Our Case Number: ABP-317809-23

Re: Proposed Coolglass windfarm and related works
In the townlands of Fossy Upper, Aghoney, Gorreelagh, Knocklead, Scotland, Brennanshill,
Monamantry, Coolglass, Crissard and Kylenebehy, Co. Laois.

Ár dTag | Our Ref.
TII23-124100

RE.: Proposed Coolglass windfarm and related works in the townlands of Fossy Upper, Aghoney, Gorreelagh, Knocklead, Scotland, Brennanshill, Monamantry, Coolglass, Crissard and Kylenebehy, Co. Laois.

02036.00787.0131.0 Turbine Delivery Route

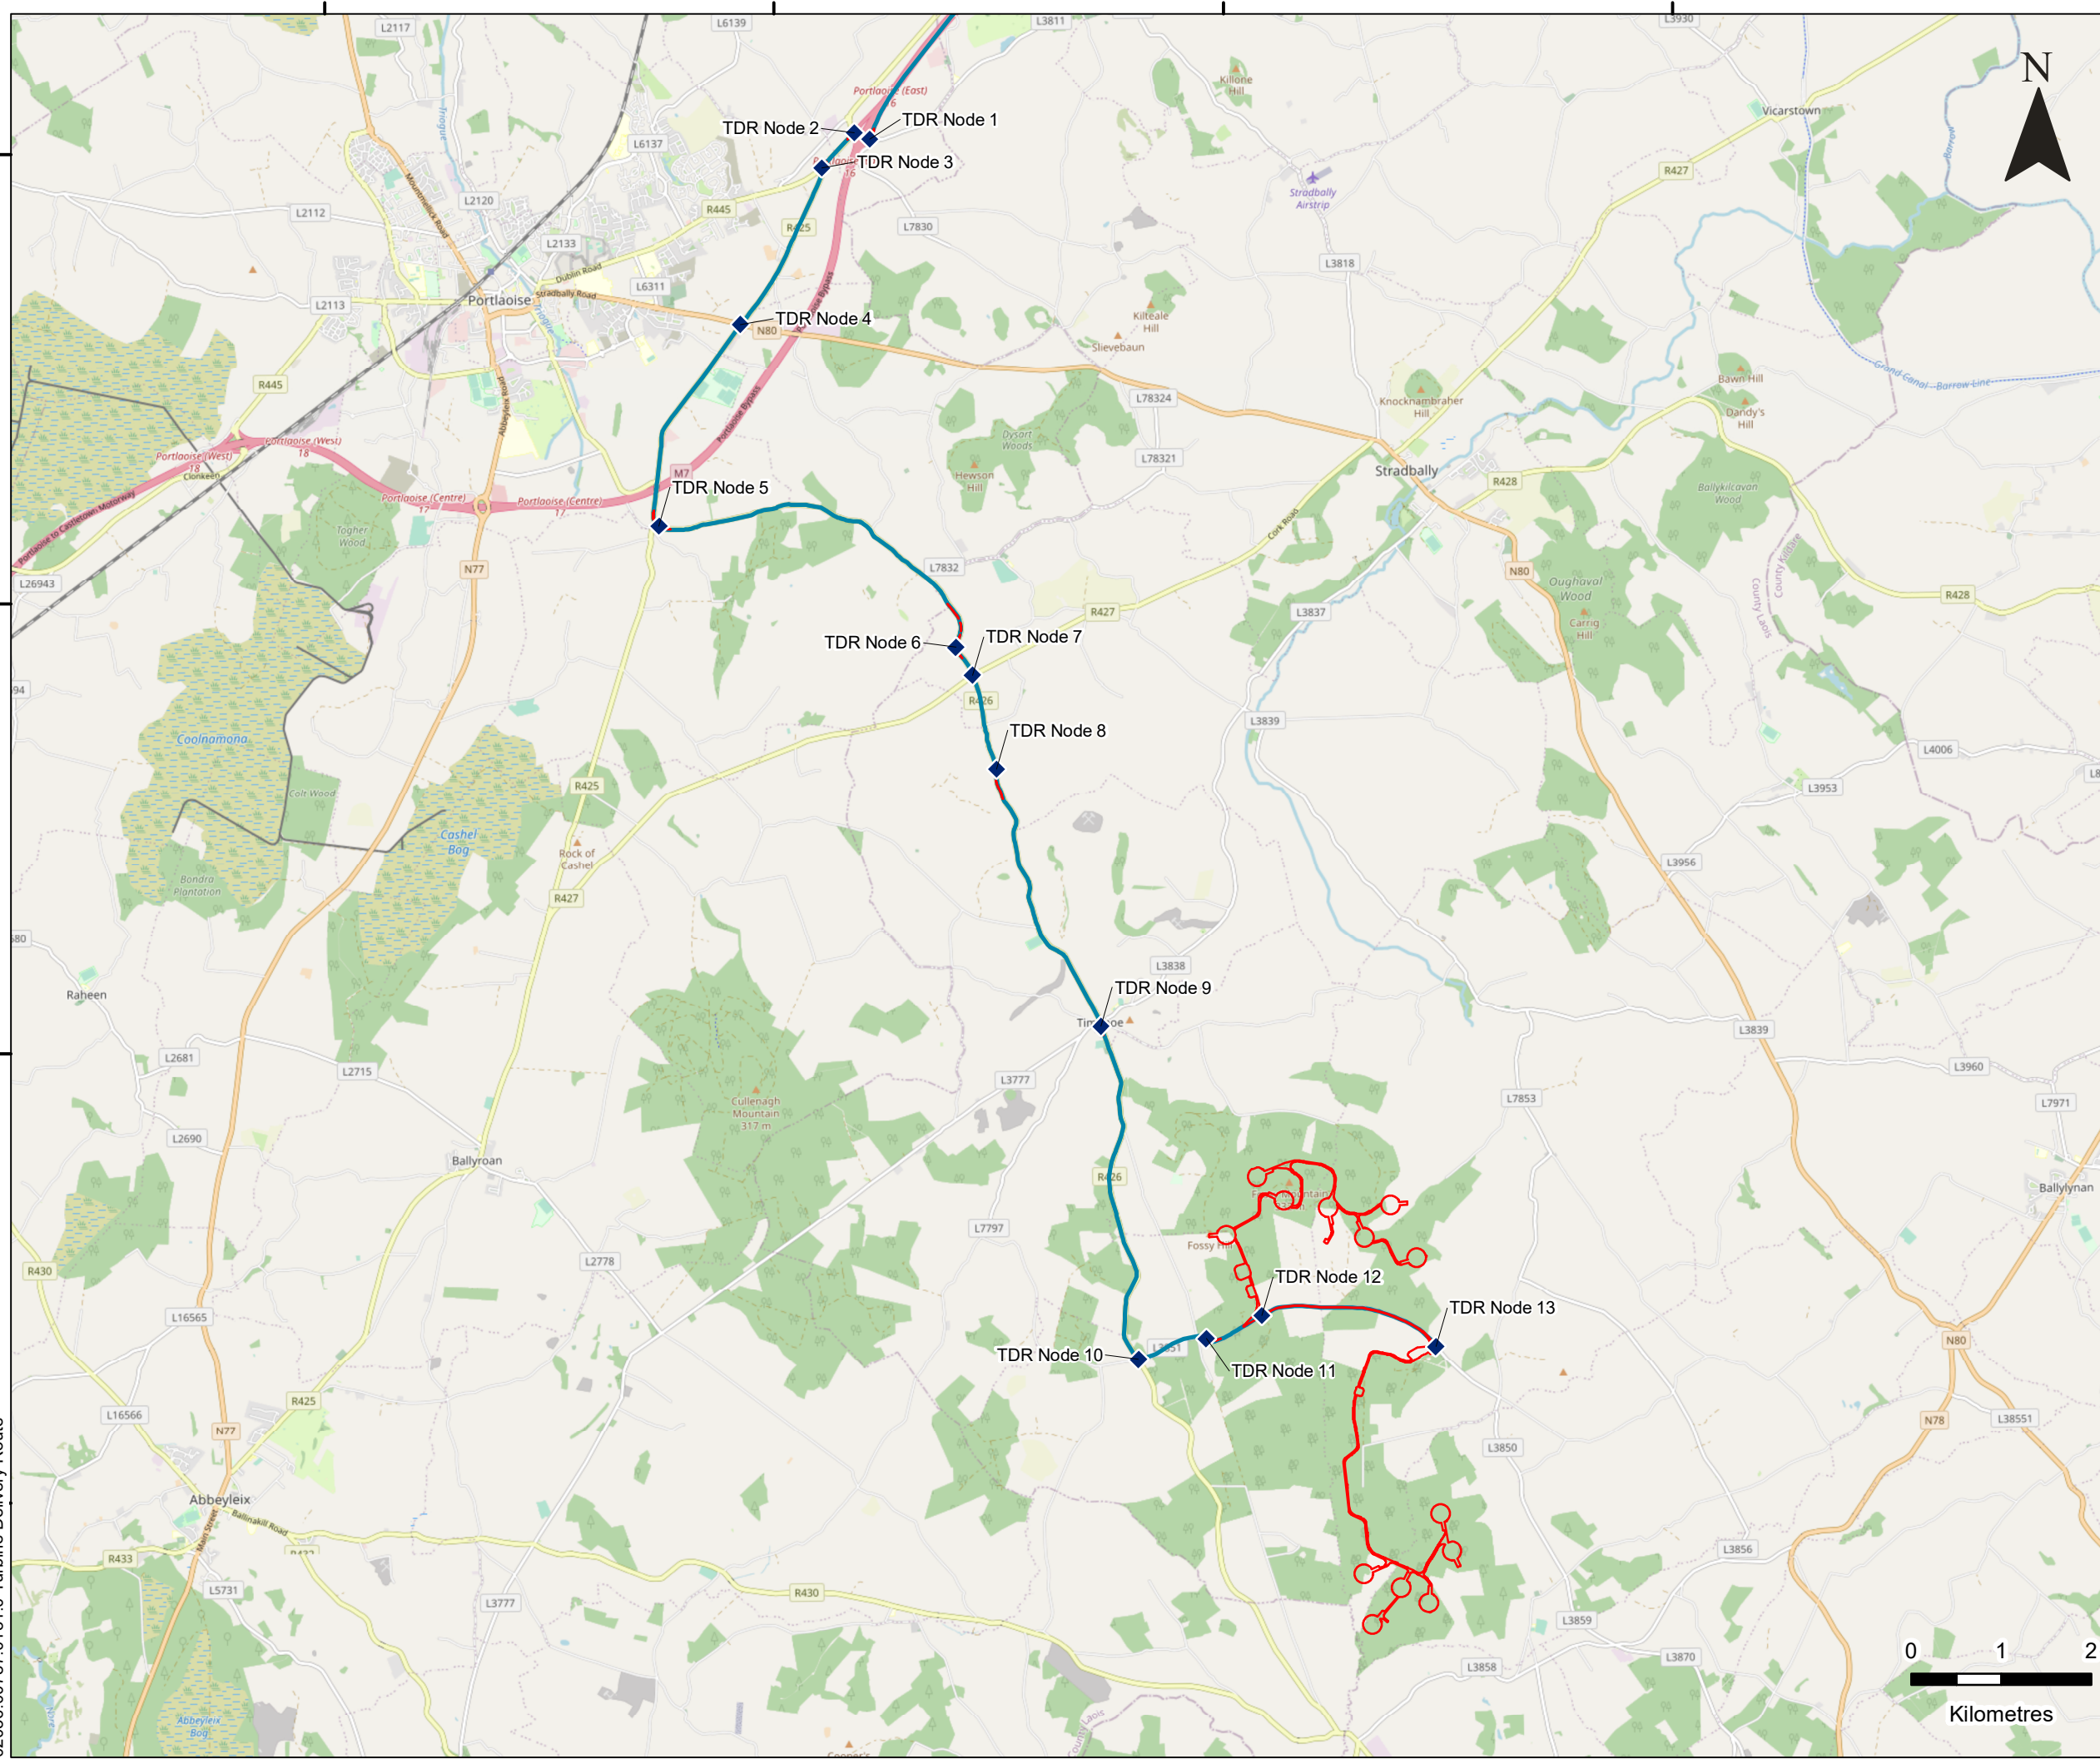
A proposed Turbine Delivery Route (TDR) is depicted at Figure 3-5 *Proposed Turbine Delivery Route Overview* which is repeated as Figure 12-5-a. The route identifies 'nodes' where accommodation works appear to be required for the TDR as each identifies a red lined "*proposed development site boundary*". Certain of the 'nodes' i.e. 1, 2 and 4 include parts of the national road network.

Nodes 1 and 2 are identified at Figure 12-5-b and encompass the M7 interchange of Junction 16 (Portlaoise East) with the R445. The entire of this dumb-bell junction is within MMarC Area C and the M7 overbridge at its centre is a TII Structure.

Node 4 is identified at Figure 12-5-d and indicates the utilisation of the R425 that at its roundabout junction with the N80 includes a portion of the "*proposed development site boundary*" indicating works to be undertaken on the N80.

It is further noted that the TDR proposes to utilise the R425 that crosses the M7 by overbridge which is also a TII Structure.

1. The applicant shall submit revised documentation and plans demonstrating the requirements of TII Publications and have regard to the extents of the Motorway Maintenance and Renewal Contracts (MMaRC) Maintenance Area C in the proposed development. As part of this exercise, the Authority recommends the submission of a drawing that identifies the extents of the MMaRC area C relative to proposed works alongside a schedule of the TII Publications applicable and intended method of compliance with TII Publications.
